From: Andrew MacGee <Andrew.Macgee@campbelltown.nsw.gov.au>
Sent: Wednesday, 15 February 2017 12:08 PM
To: Kerry Hamann; RATHAN Pahee
Subject: RE: Response to Submissions - Joe White Malting (Cargill) MP 08_0157 Modification 4 (email 2)

Council has reviewed the additional information submitted by Cardno on behalf of Joe White Malting, Minto.

Figure 3 Inbound Operational Truck Route from the South

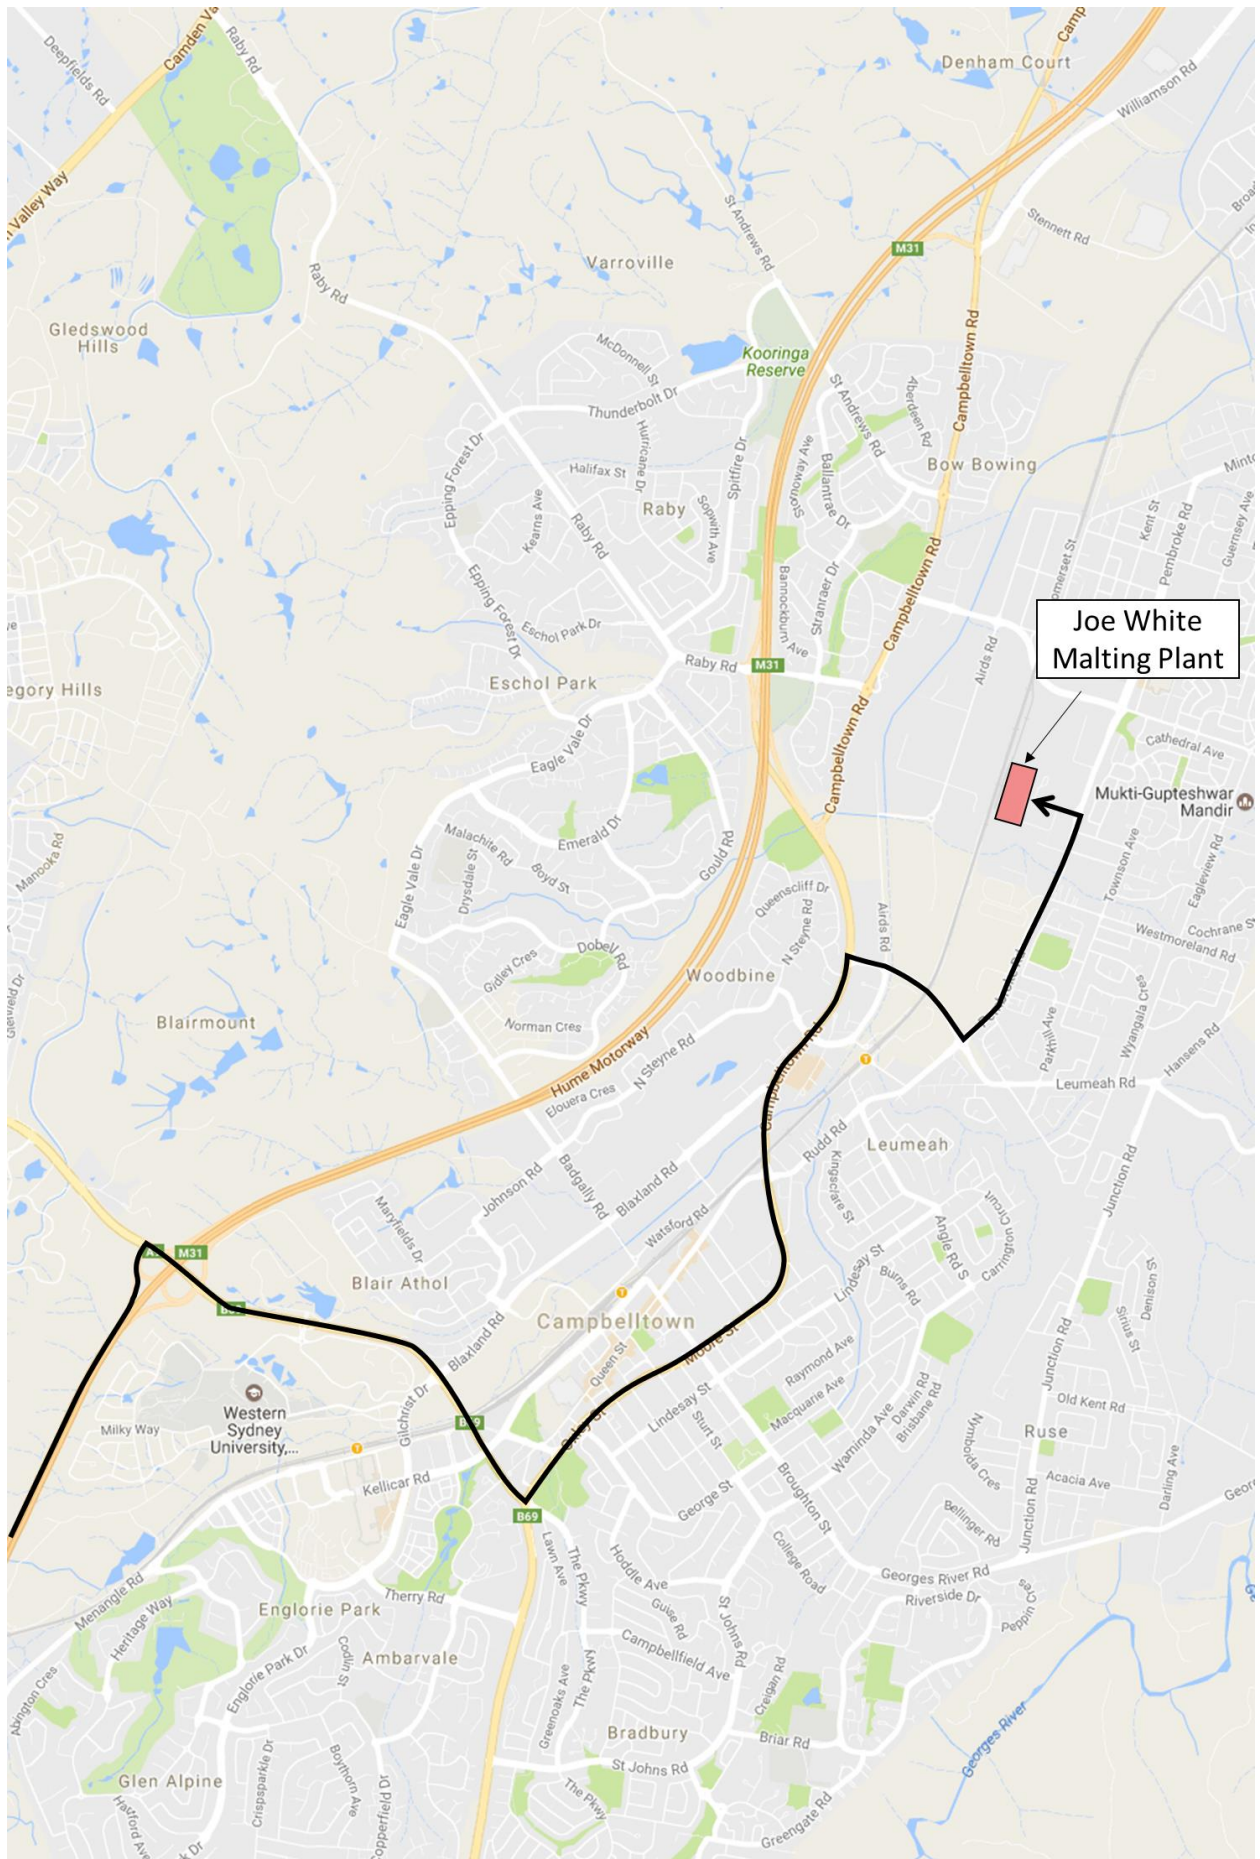
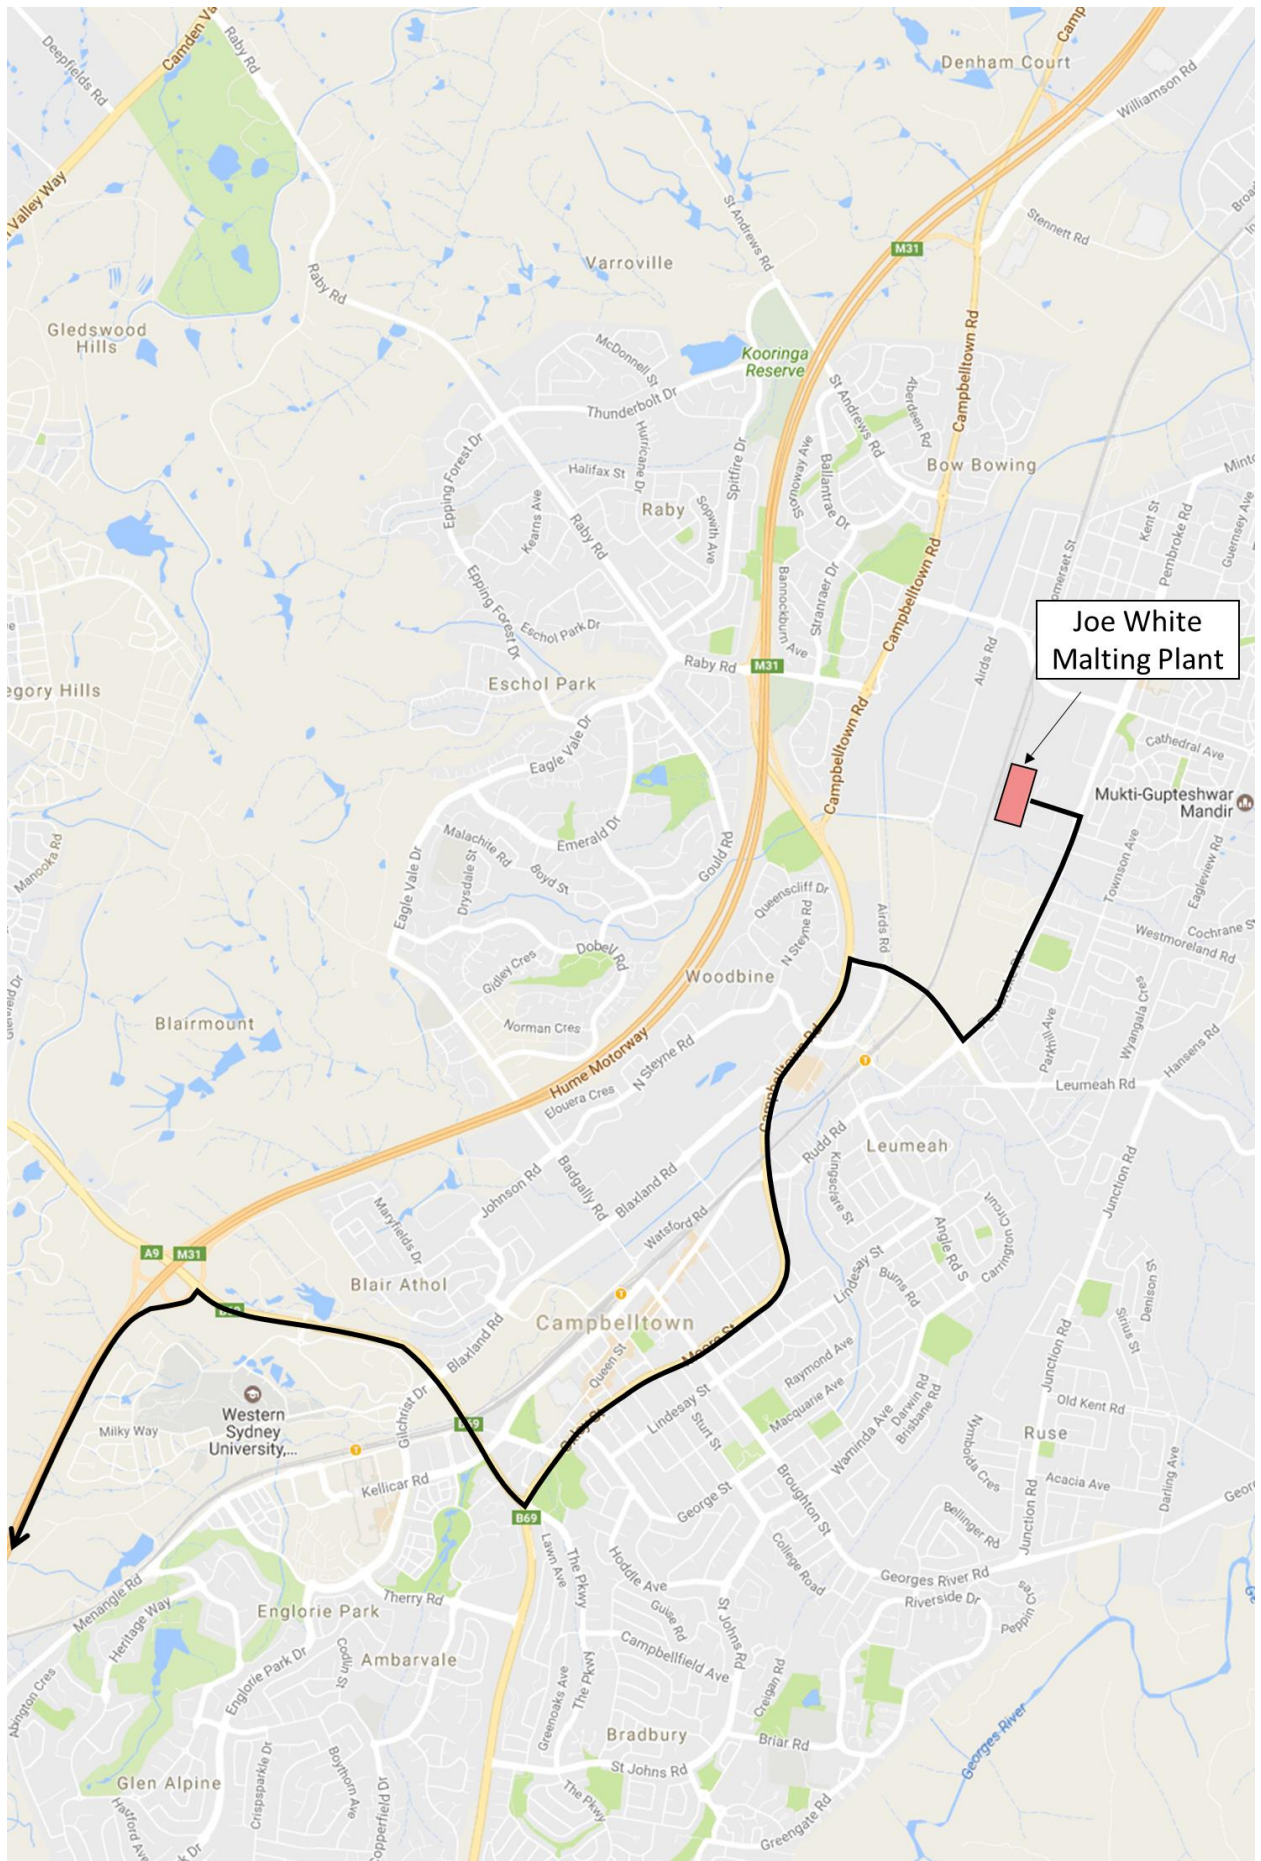
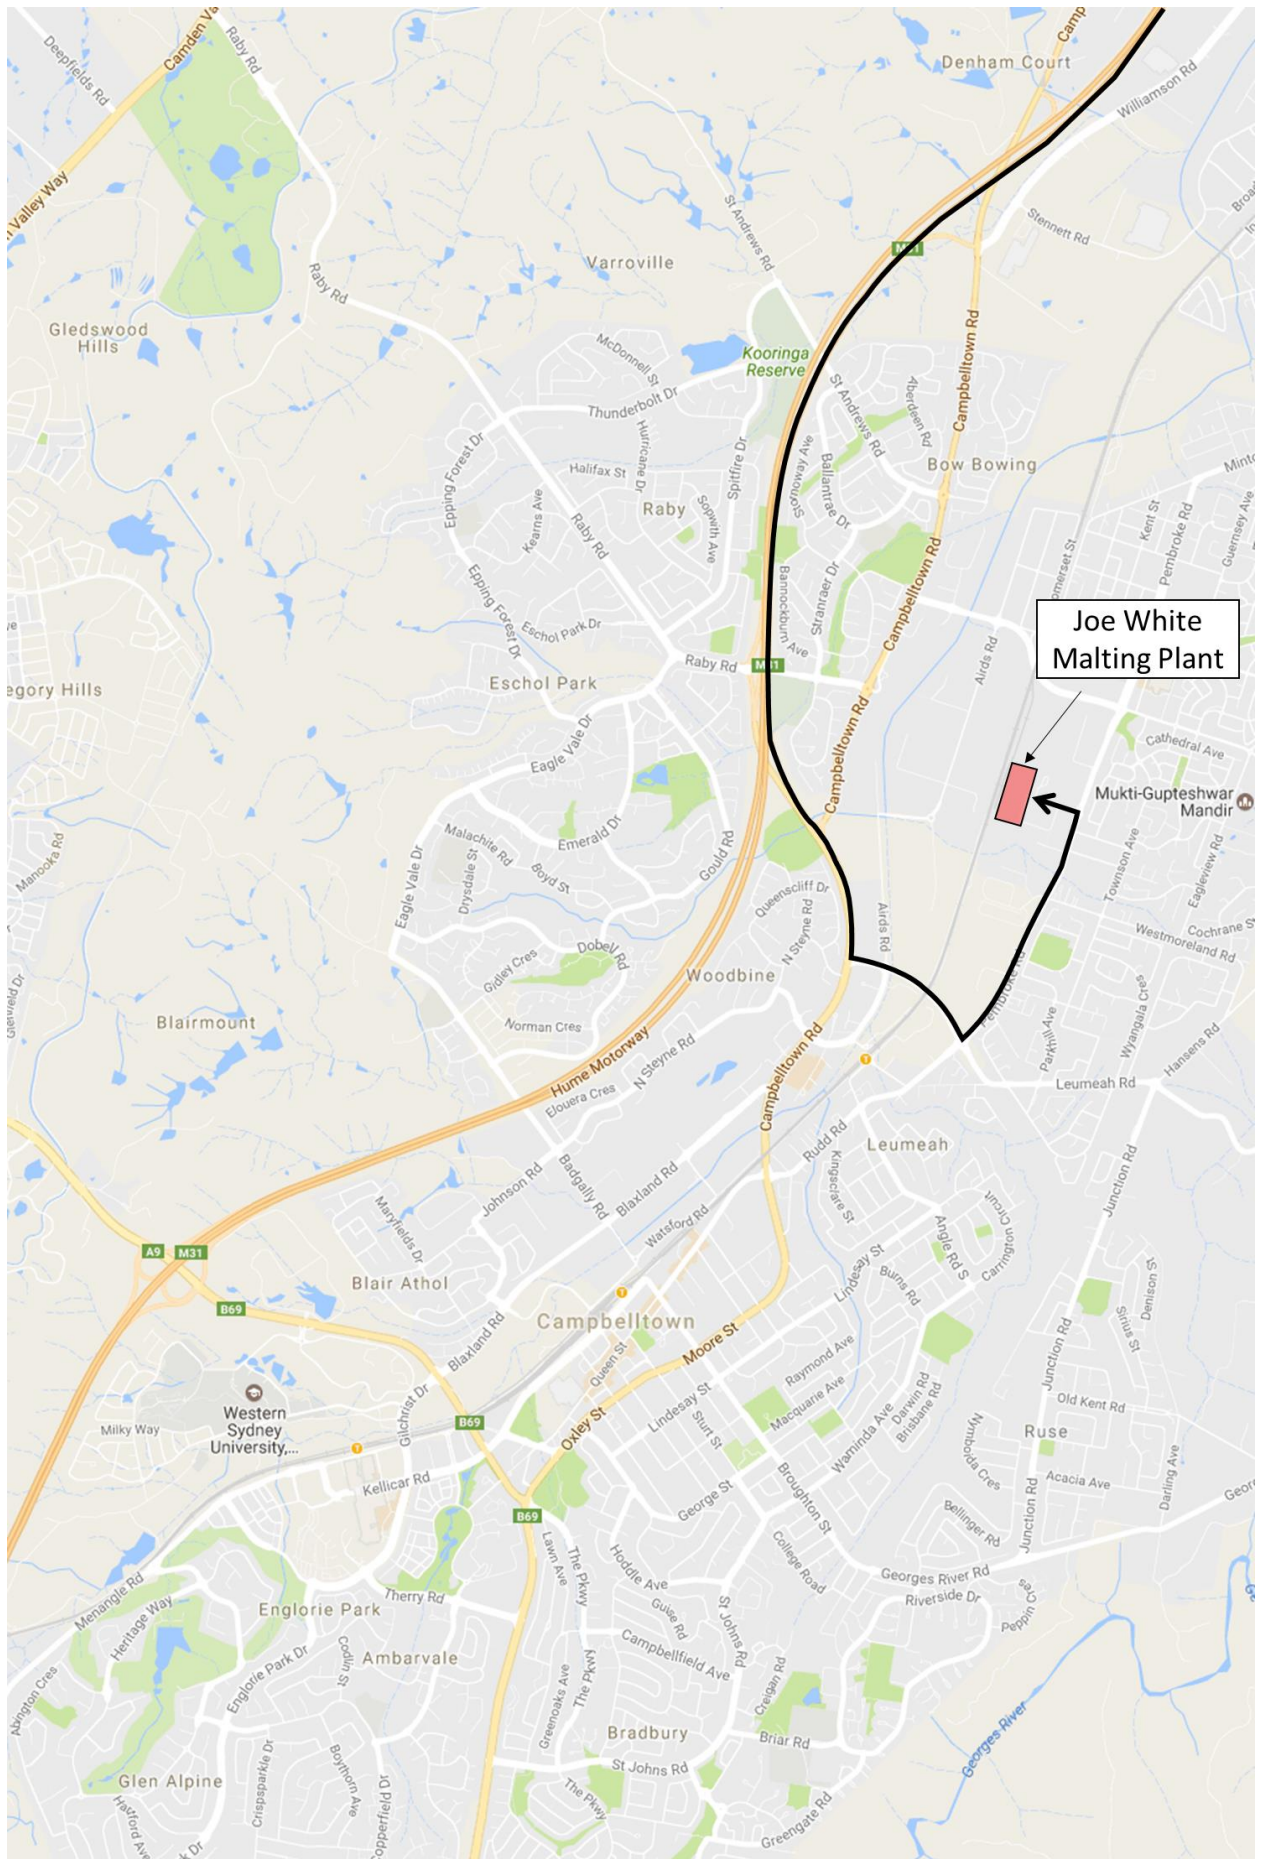
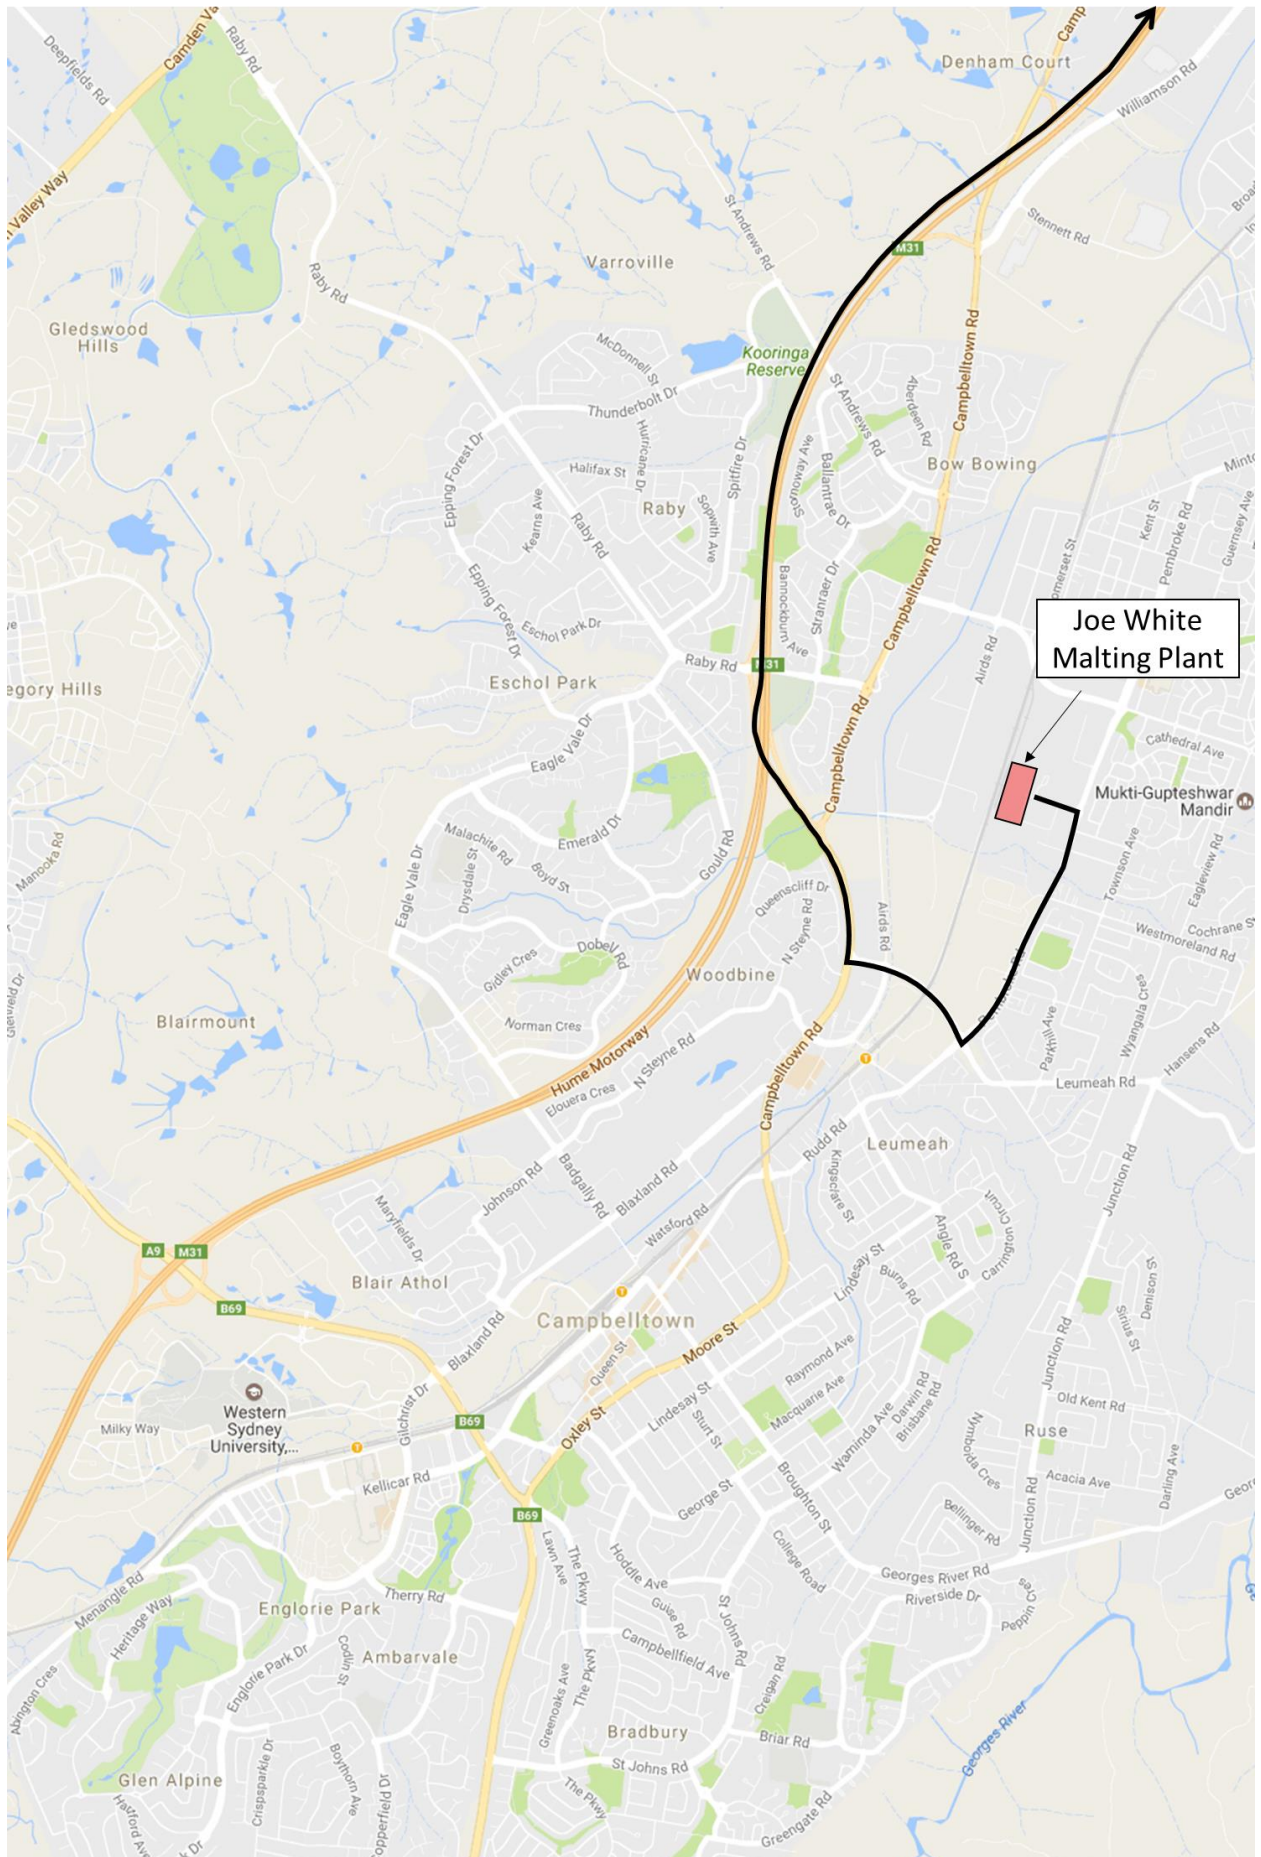
- The truck routes on page 6 and in Appendix C of the proponent's 'Operational Traffic Management Plan' do not appear to consider the 40 tonne load limit that is applied to the bridge on Ben Lomond Road (between Airds Road and Carey Grove). Further, the right turn proposed from Campbelltown Road to the Hume Highway north is not possible. There are no right turn facilities in that location. A revised route for those movements impacted by the load limit and turn treatments shall be provided.
